**WEST SUSSEX COUNTY COUNCIL
PLANNING SERVICES CONSULTATION**

SUBJECT: A/3/18/PL - Change of use of land to storage (B8 Storage or Distribution), erection of barn & hardstanding (resubmission following A/111/17/PL).

Land at Arundel Road/A27, Angmering, BN16 4EU

RECOMMENDATION:

Drawing:
1711056-SK01

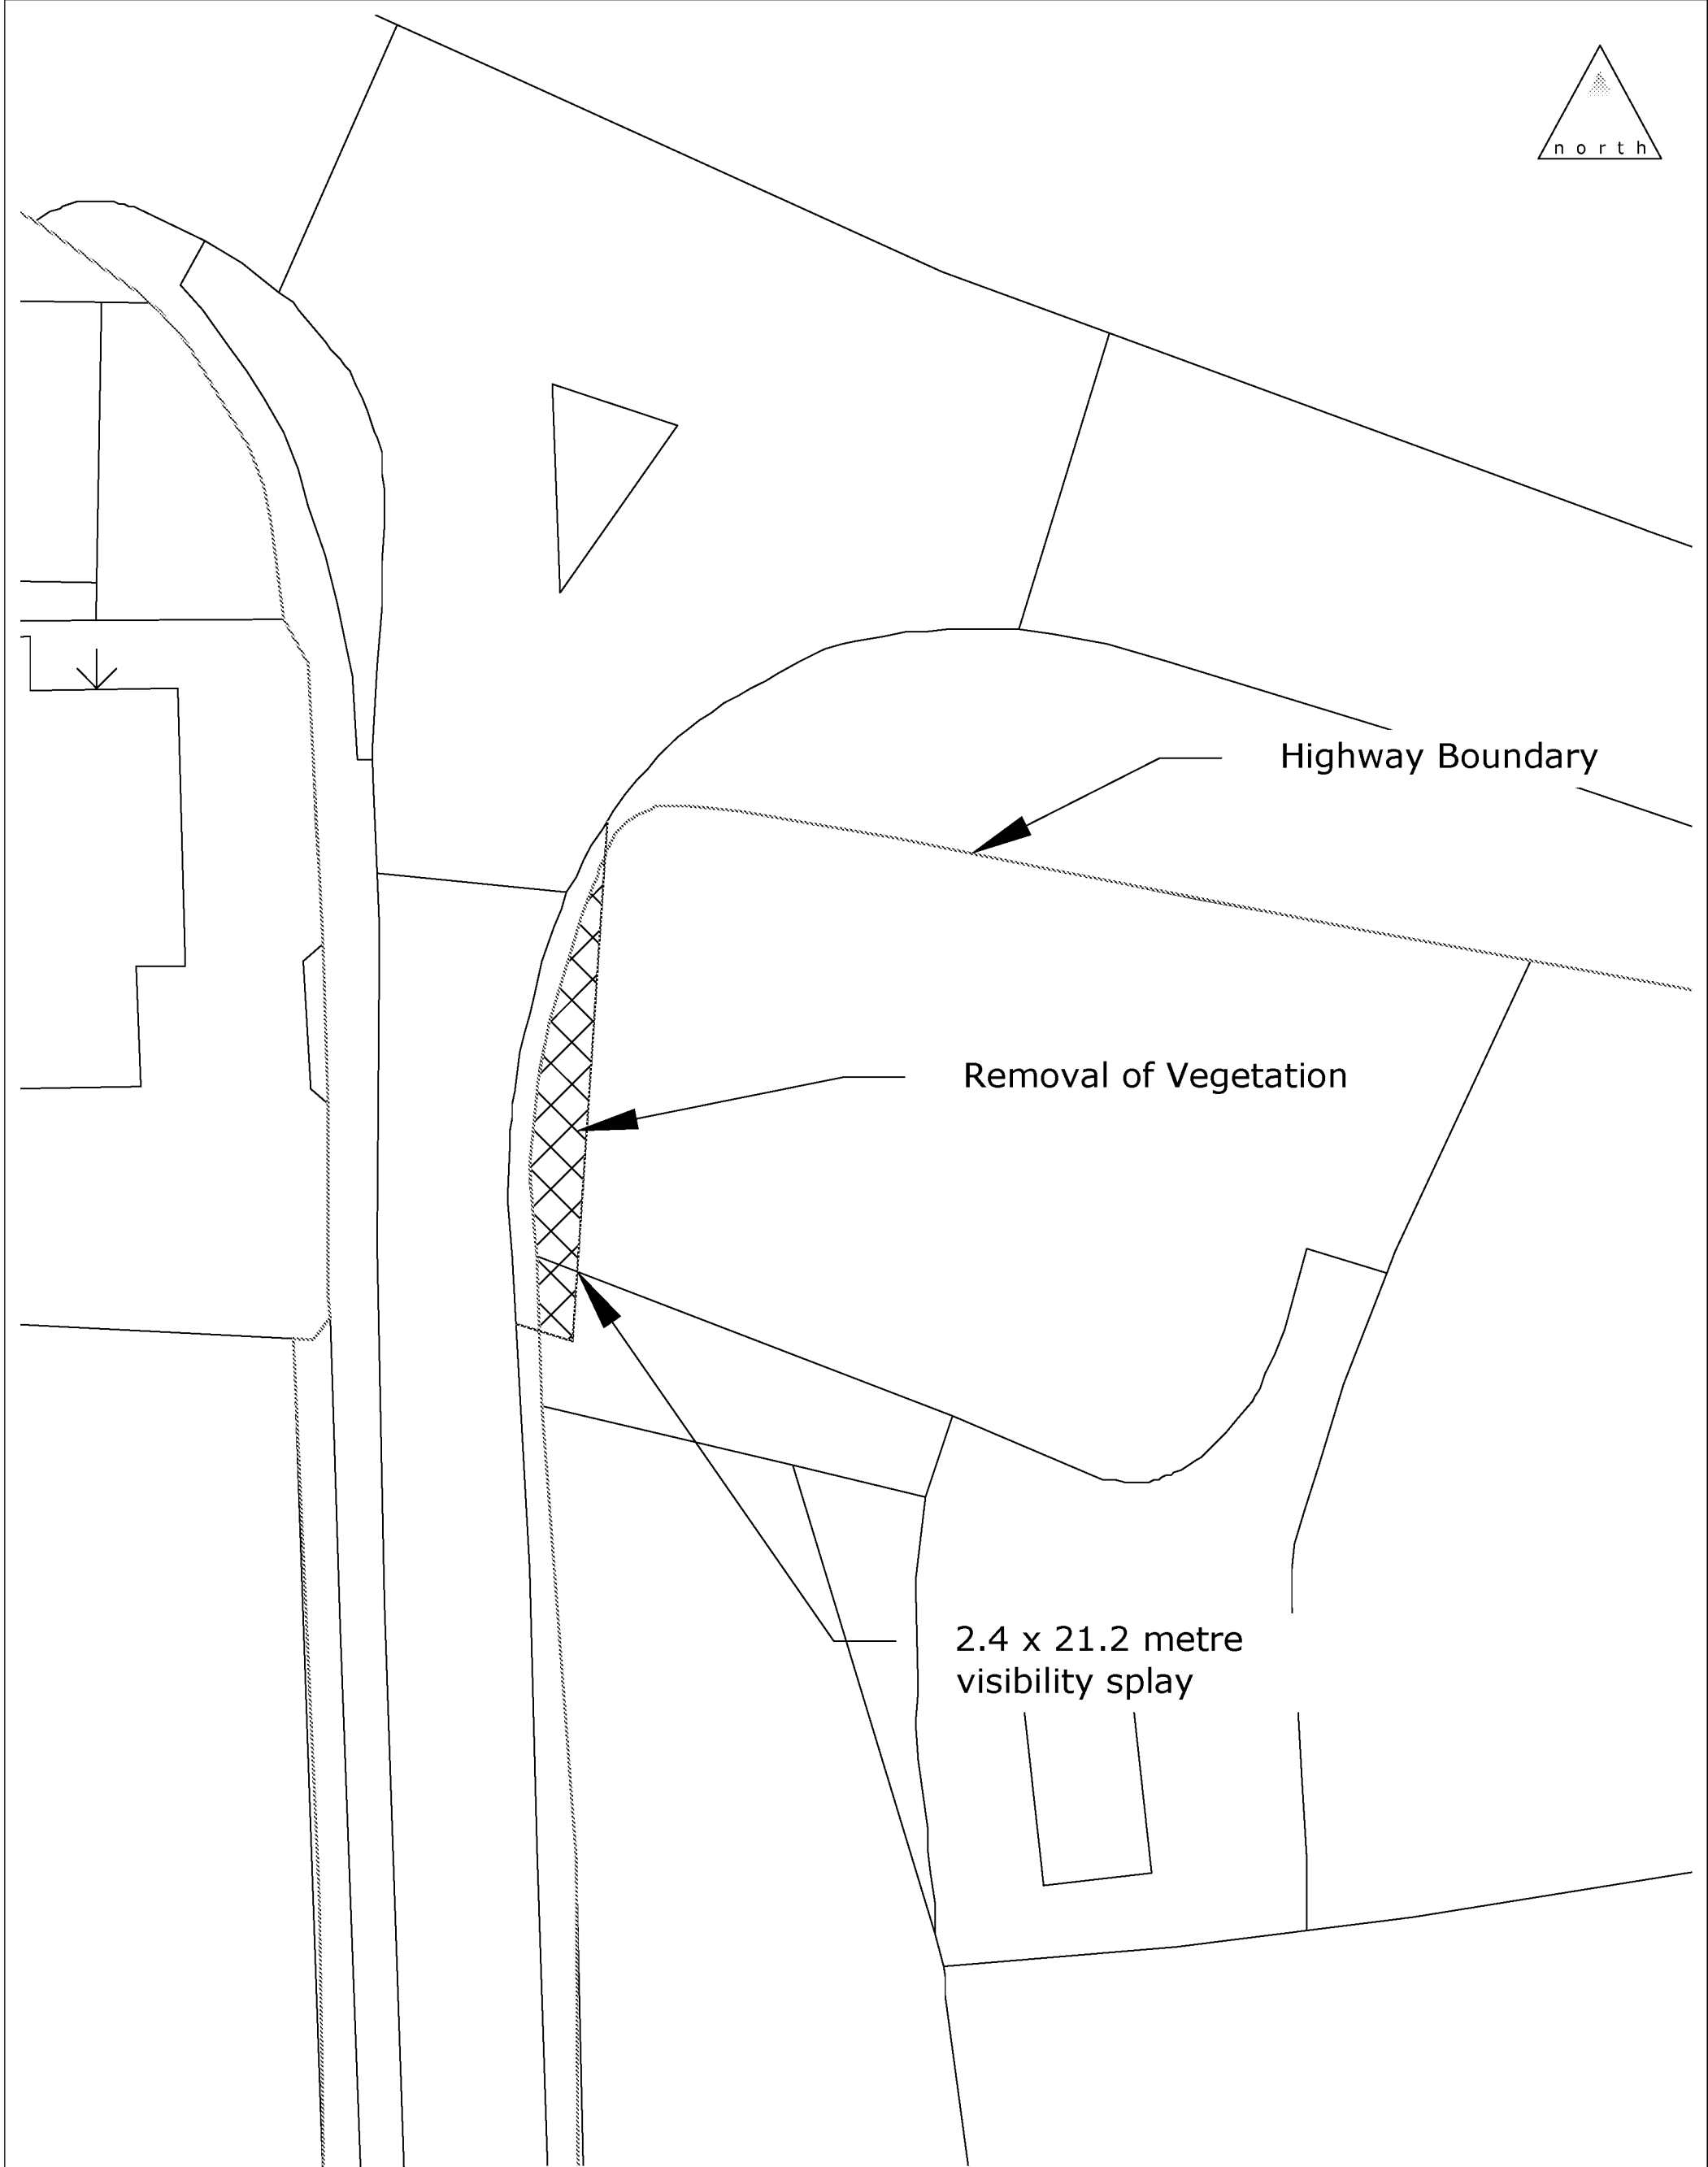
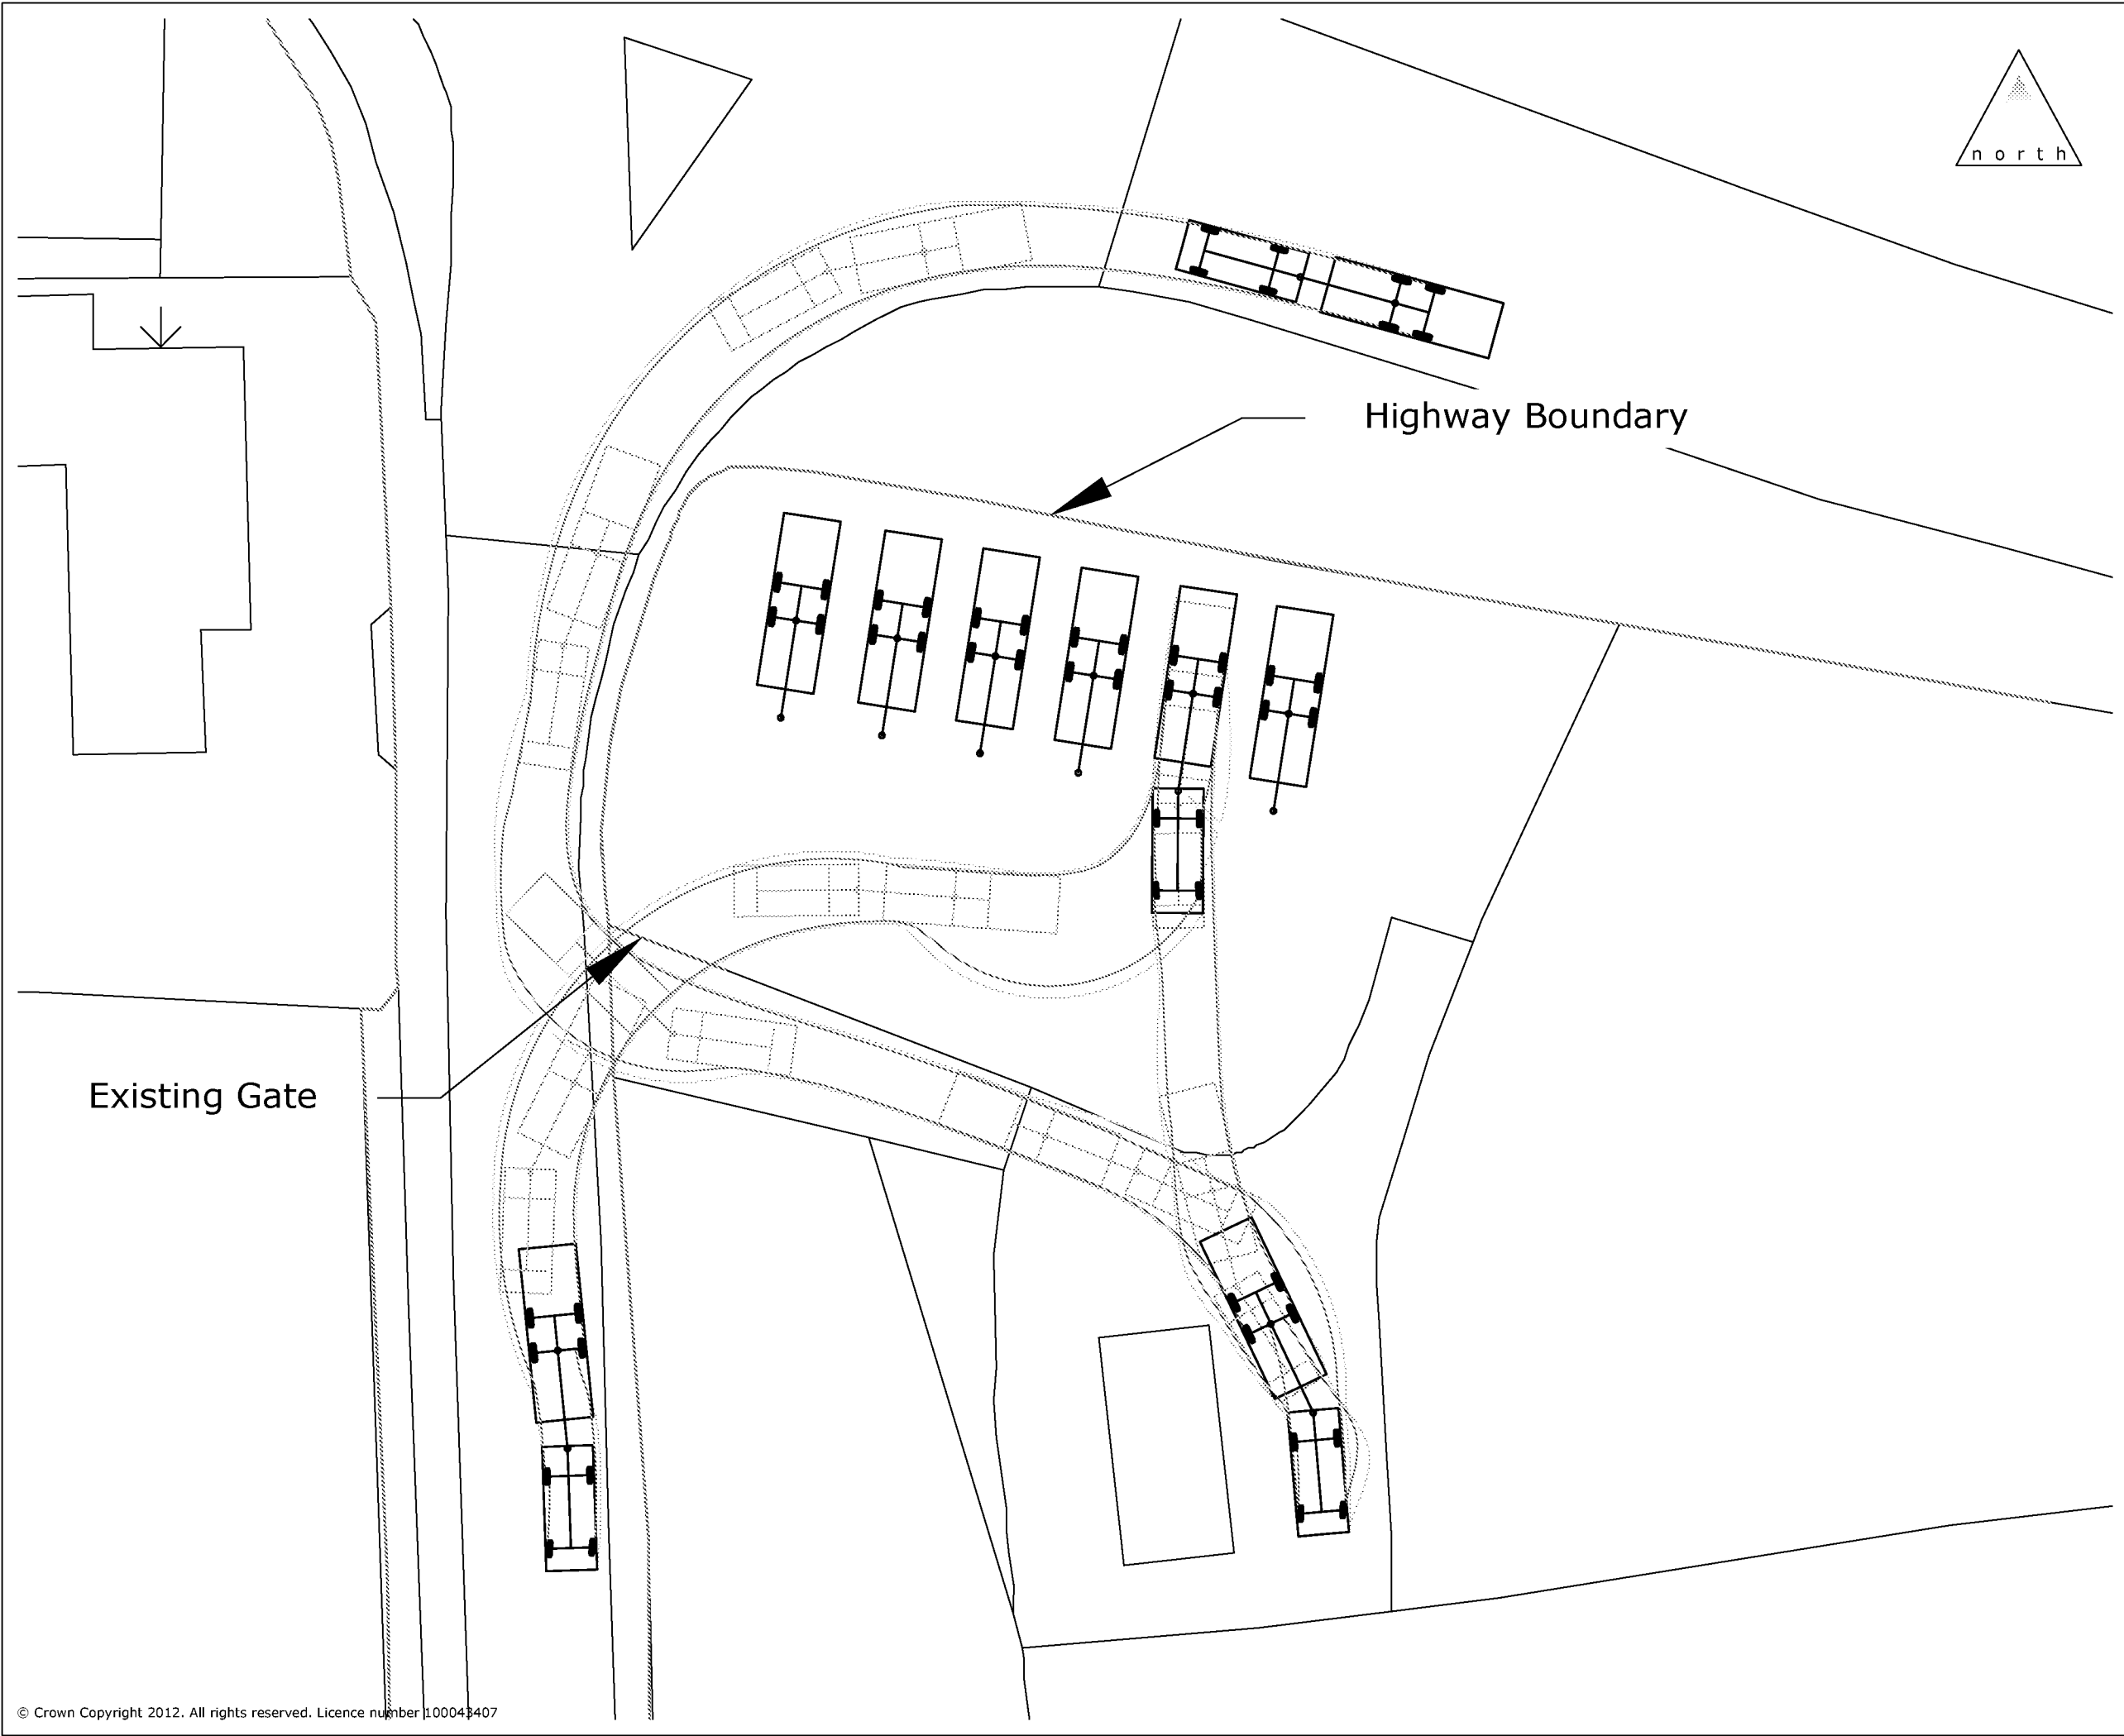
The Technical Note has satisfactorily demonstrated that such a splay of 2.4 x 21 metres is achievable and would be considered an improvement against the existing situation.

The Local Planning Authority would be advised that the formation of such a splay is going to have a significant impact upon the vegetation boundary in this location, and may require the removal a mature tree.

No significant additional assessment has been made with regard to visibility south of the access point. Other than overhanging vegetation clearance the opportunity for improvement is limited due to 3rd party land ownership and the lack of a wide highway verge.

It has been acknowledged in paragraph 2.12 of the Technical Note that visibility to the south is substandard.
